Please ask for: Mrs D Johnson
Email: daun.johnson@arun.gov.uk
Telephone: 01903 737762
Our Ref: BE/149/20/PL
Your Ref:
Date: 15th December 2020

Application for Planning Permission

Development: Replacement of blockwork boundary wall with fence & new vehicular access. This site is in CIL Zone 4 (Zero Rated) as other development.
Location: 339 Chichester Road Bersted PO21 5AN

SITE PLAN

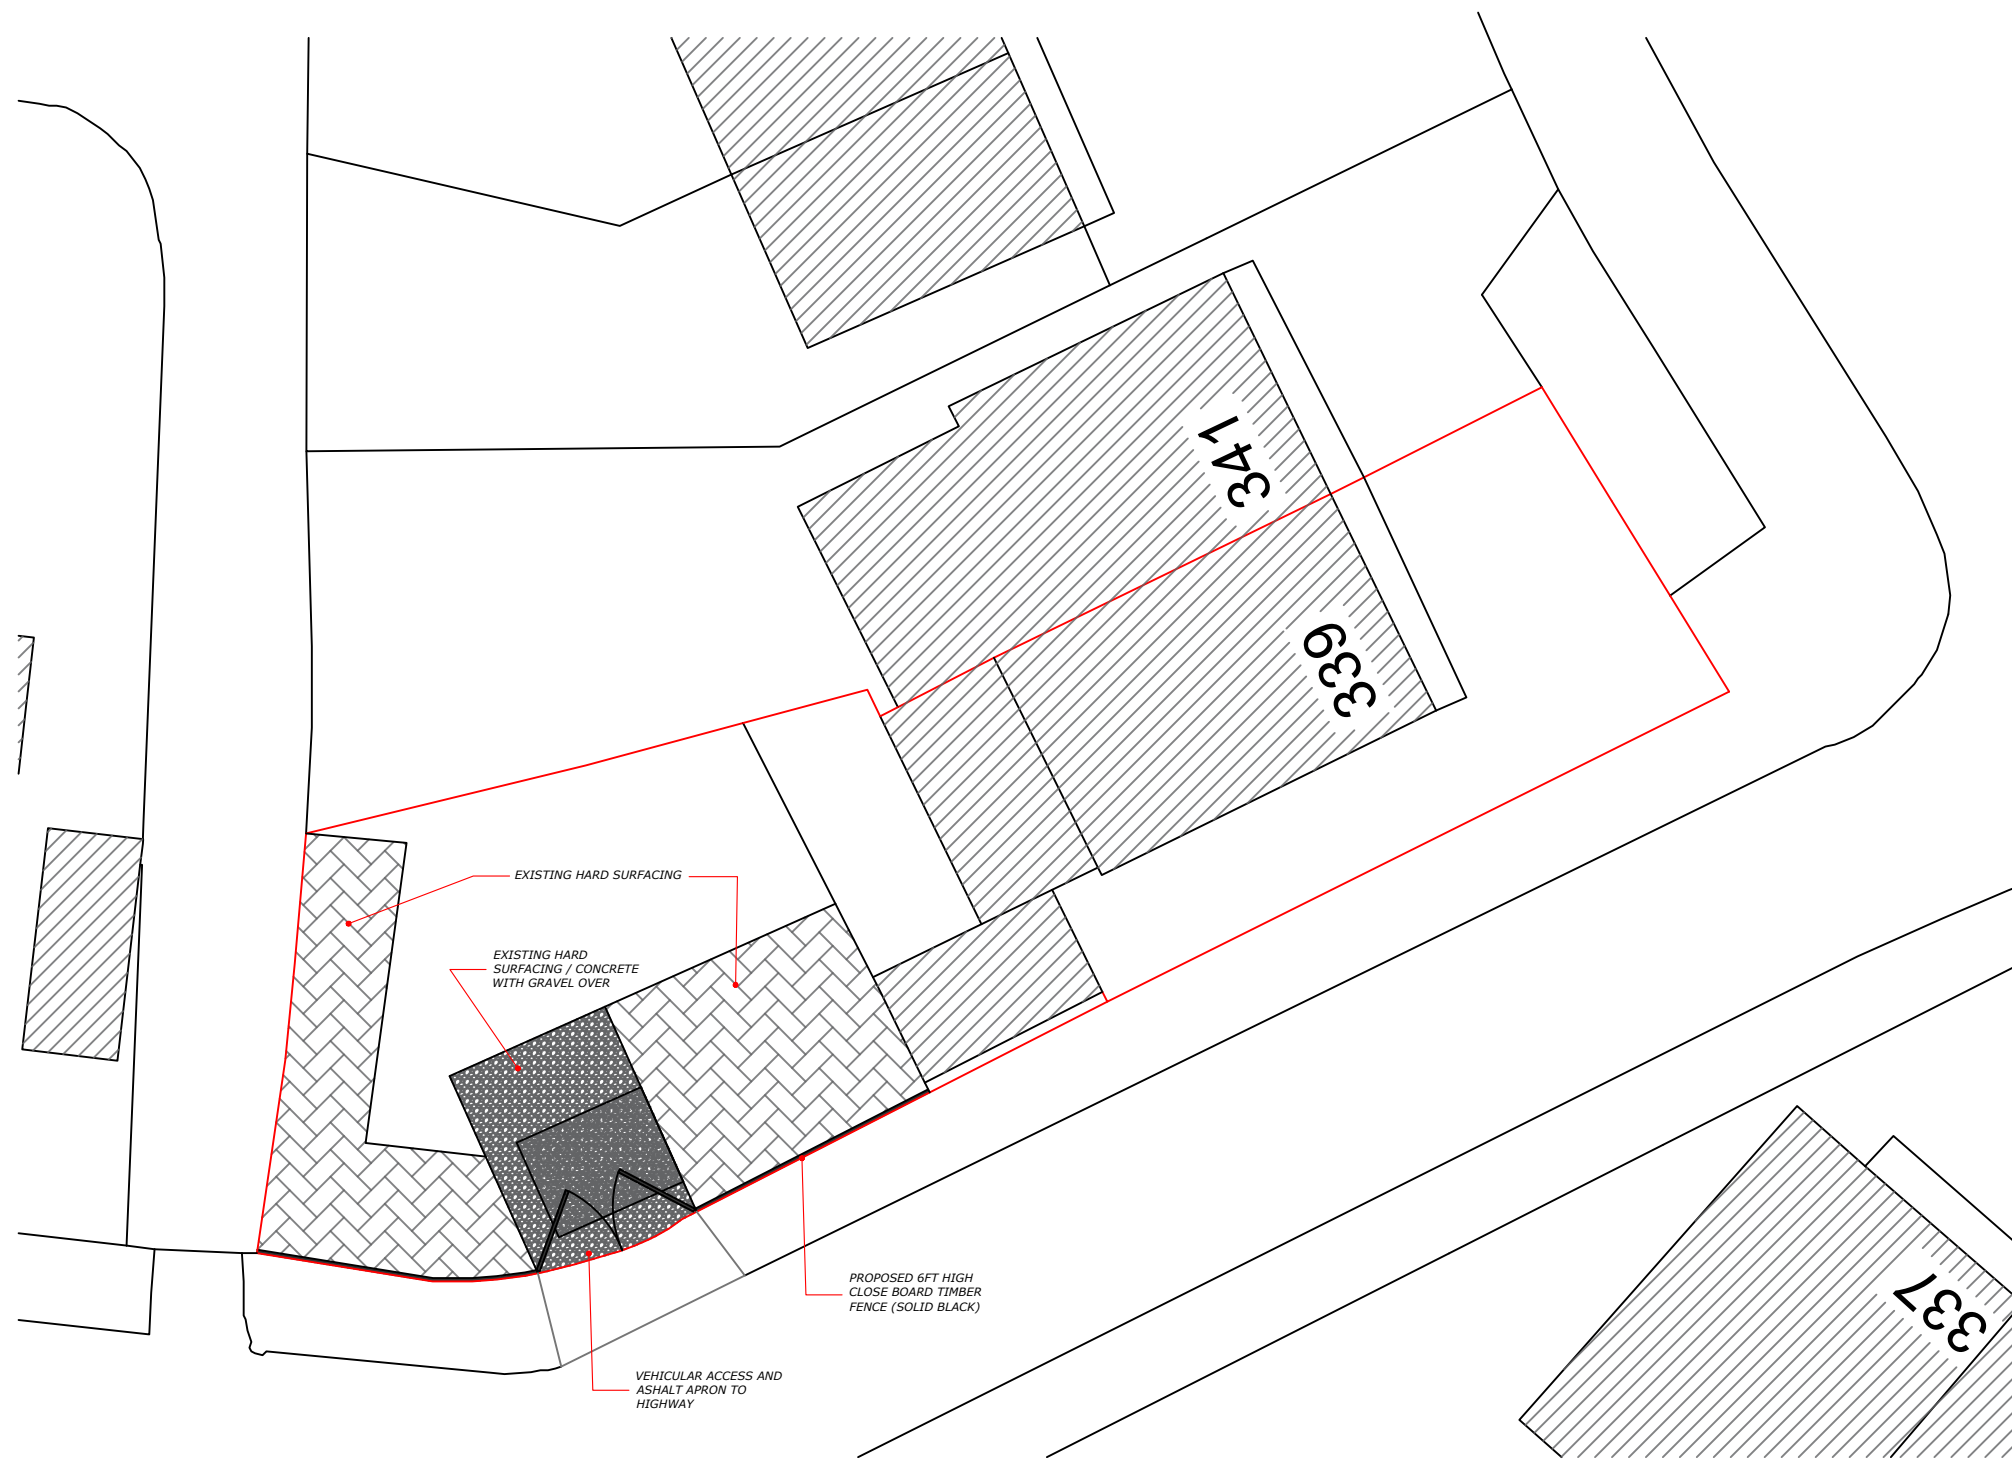
Block Plan

Please clearly highlight the position of the proposed fence.

Please provide a photo or plan of the proposed fence.

West Sussex County Council require that a visibility splay is provided. A splay is formed for a 30 mph speed limit road by measuring from a point 2.4m back from the kerb edge in the centre of the proposed access. A line should then be drawn from either side of this point for 43 m in each direction to the nearside edge of the carriage way. The splays must intersect land only within the control of the applicant, or within the publicly maintained highway.
